Your ref: SSD 7228  
File no: MC-15-1942

**Re: SSD 7228 Sydney Zoo, Bungarribee Park, Western Sydney Parklands**

## **ATTACHMENT A**

DRAWING STATUS			SHEET SIZE	
E.I.S. EXHIBITION			A1	
DRAFTSMAN J.Fraser	DESIGNER T.Walton	PROJ MANAGER T.Walton	SCALE 1:1000	
PROJECT REF No. 12082		DRAWING No. DA02		REVISION B

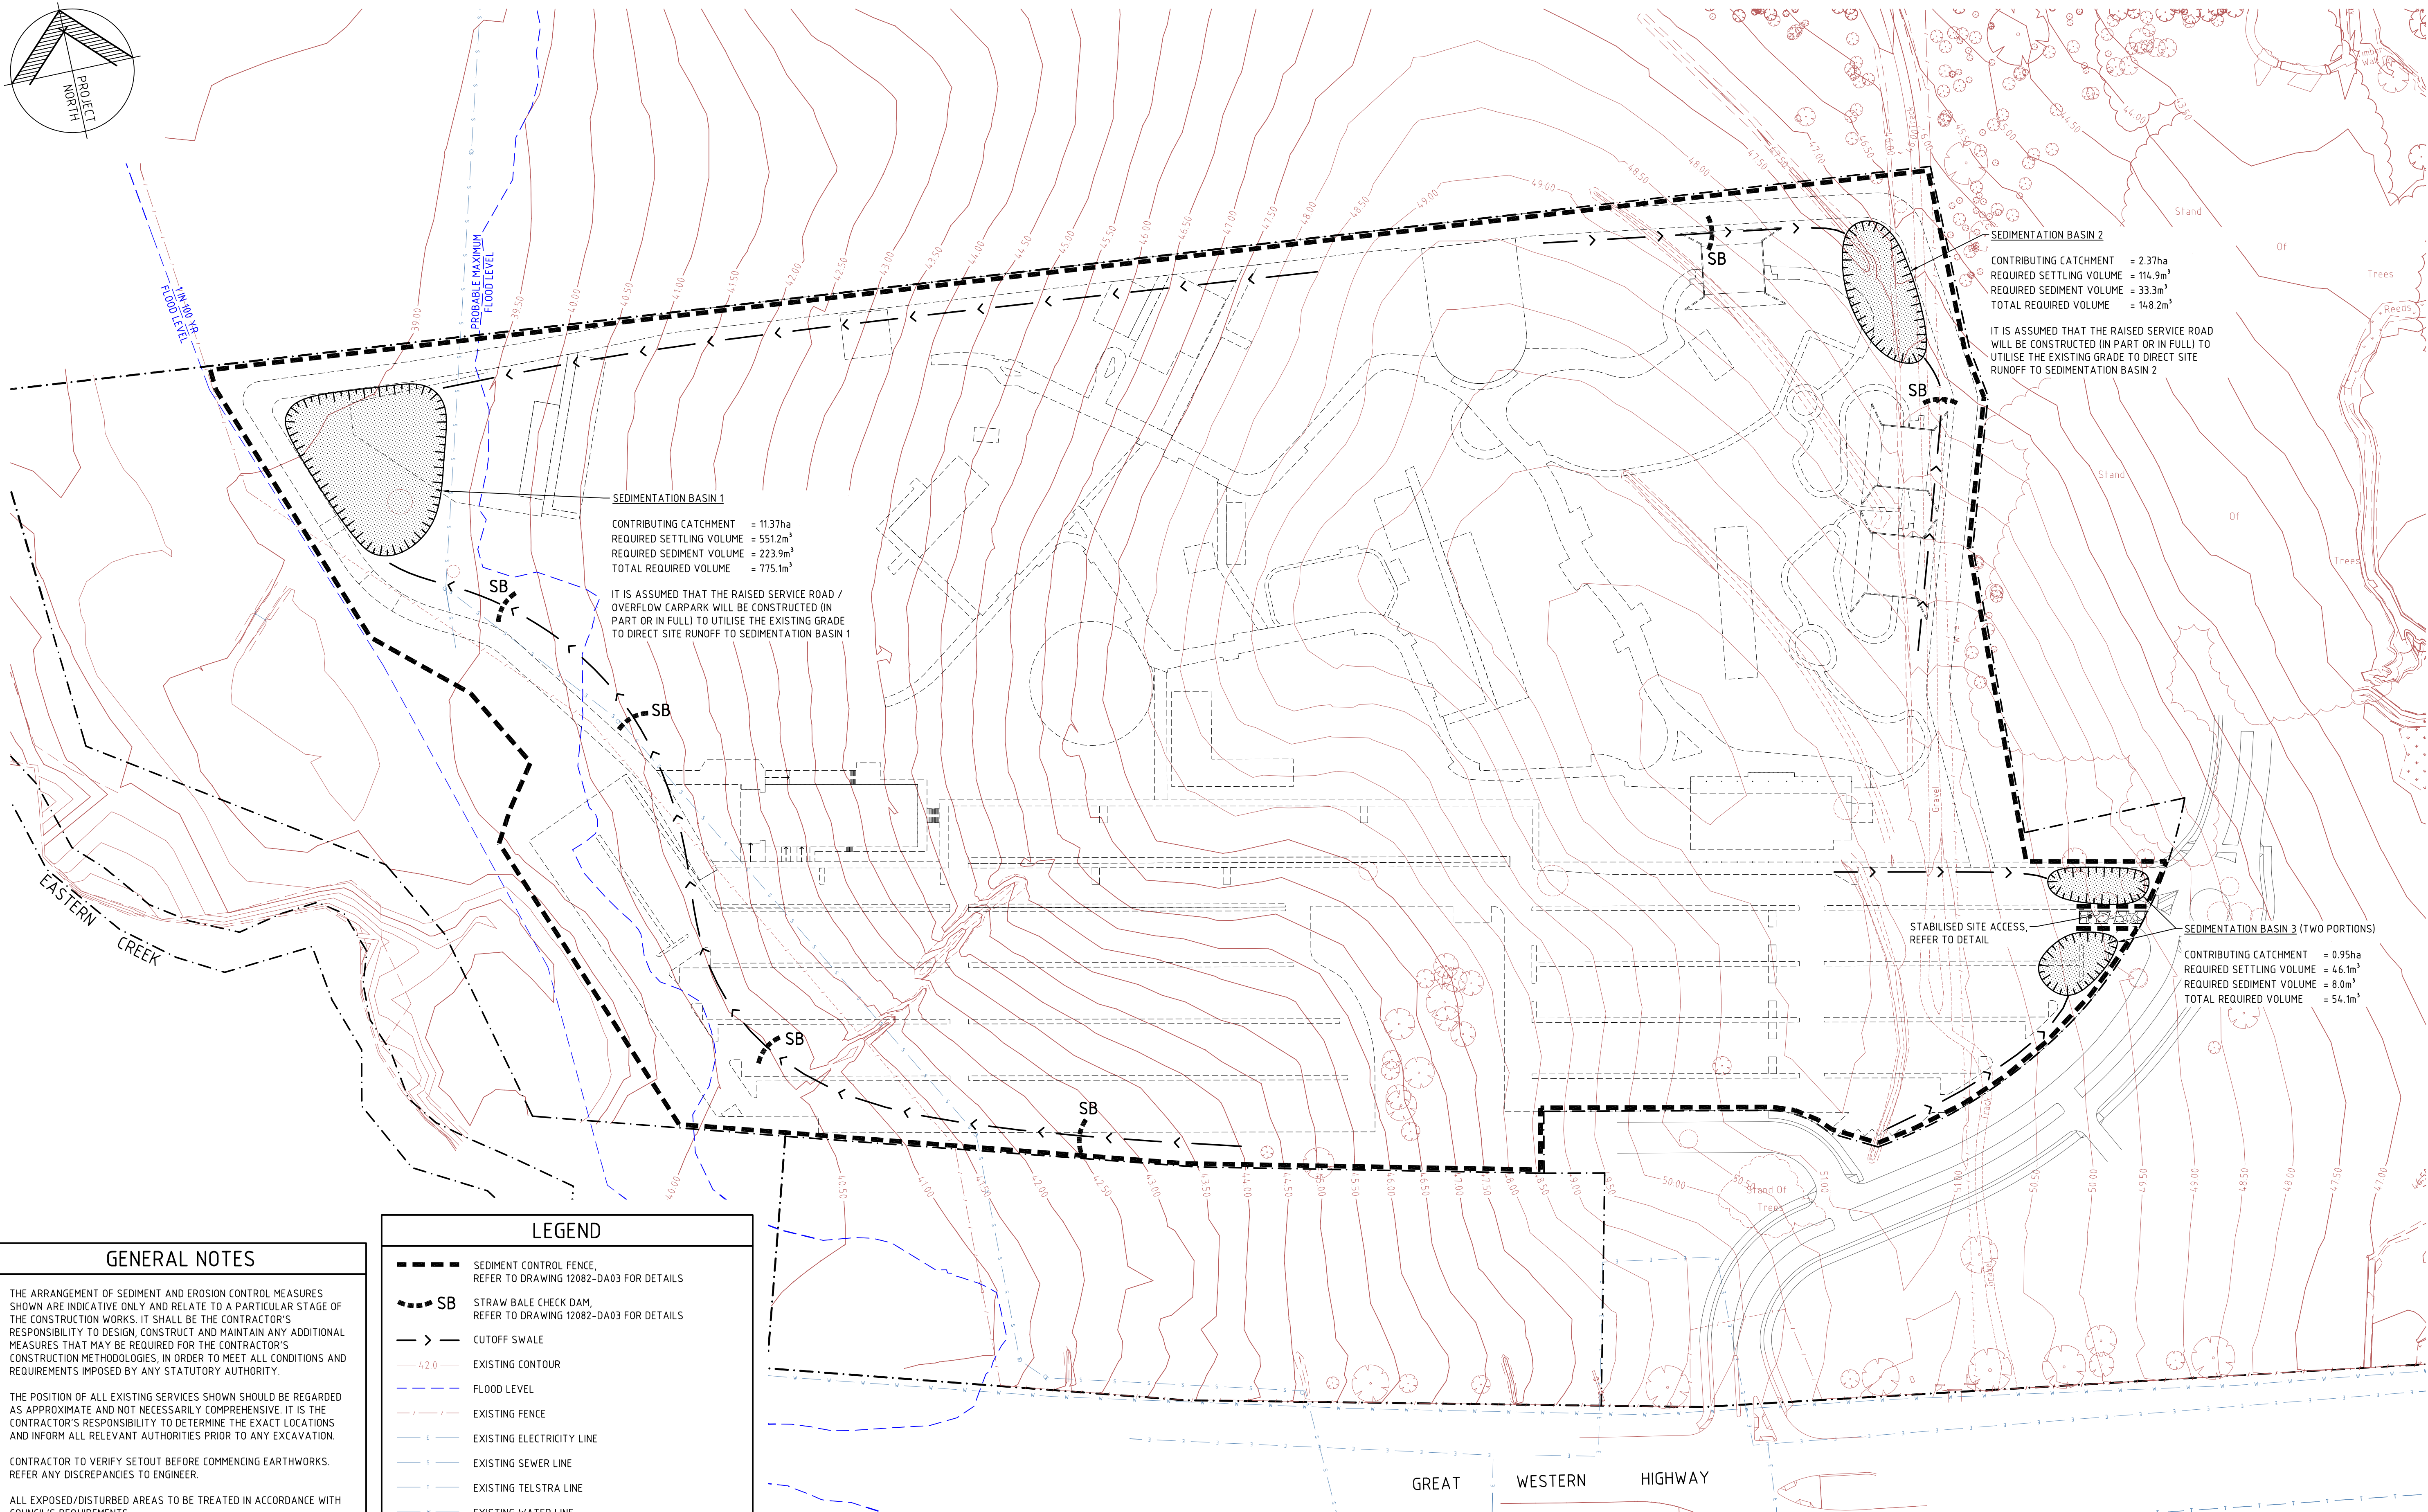
31. Design an on-site detention basin to mitigate all post developed flows from the site to not exceed pre developed rural catchment flows (with an initial pervious loss of 15 mm) for all storm events from 1 in 2 year ARI to 1 in 100 year ARI. This design is to

be supported by electronic modelling that complies with the requirements of the Council's Engineering Guide for Development 2005 and account for any bypass of the detention basin. The DRAINS model 2015 12 03 - EIS Exhibition - Drains.drn provided in support of the application does not use the required 15 mm initial loss for the existing rural site, but used 5 mm initial loss which is only applicable to the developed site. This significantly overestimates the allowable discharge rates. None of the targets have been achieved. A two stage outlet control plus weir is required to manage the various flow rates. Provide pre and post as two separate models.
